**City of Portland, Maine - Building or Use Permit Application**  
 389 Congress Street, 04101 Tel: (207) 874-8703, Fax: (207) 874-8716

<b>Permit No:</b> 06-0056	<b>Issue Date:</b>	<b>CBL:</b> 425 A002001
------------------------------	--------------------	----------------------------

<b>Location of Construction:</b> 125 PRESUMPSCOT ST	<b>Owner Name:</b> PRESUMPSCOT STREET PROPERT	<b>Owner Address:</b> PO BOX 403	<b>Phone:</b>
<b>Business Name:</b>	<b>Contractor Name:</b> HardyPond Construction	<b>Contractor Address:</b> 1039 Riverside St Suite 11 Portland	<b>Phone</b> 2077976066
<b>Lessee/Buyer's Name</b>	<b>Phone:</b>	<b>Permit Type:</b> Change of Use - Commercial	<b>Zone:</b>

<b>Past Use:</b> Vacant Commercial building	<b>Proposed Use:</b> New England Organics/ Change of use to commercial office space for New England Organics/ Tenant Fit-up back half of new building	<b>Permit Fee:</b> \$807.00	<b>Cost of Work:</b> \$78,500.00	<b>CEO District:</b> 4
<b>Proposed Project Description:</b> Change of use to commercial office space for New England Organics/ Tenant Fit-up		<b>FIRE DEPT:</b> <input type="checkbox"/> Approved <input type="checkbox"/> Denied	<b>INSPECTION:</b> Use Group

New England Organics

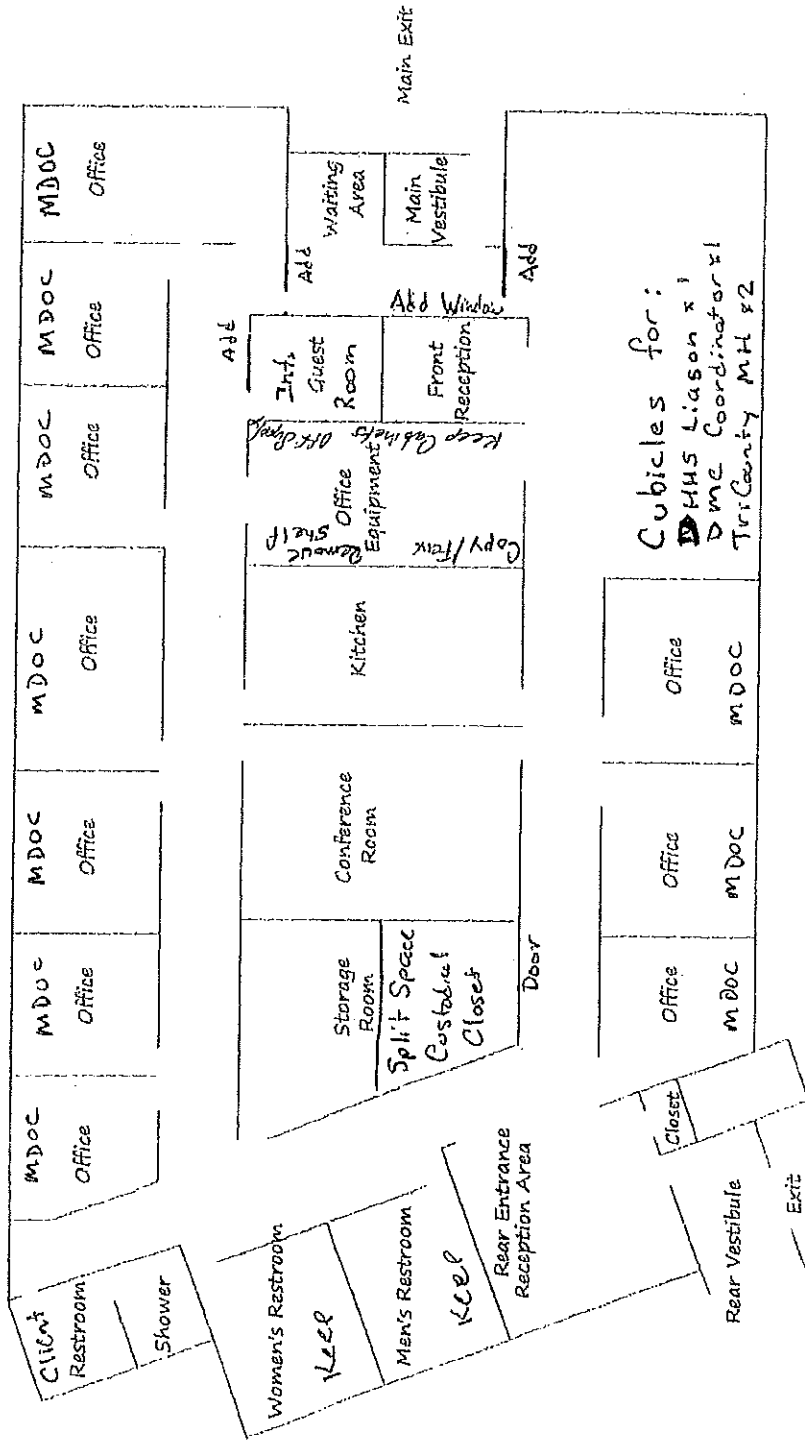
**Comments:**  
1/20/2006-mjn: have left messages with the architect, the builder and the owner. We need ADA and Building Code Certification forms, it appears that the Restroom may be too narrow for ADA standards. Need more infomation.
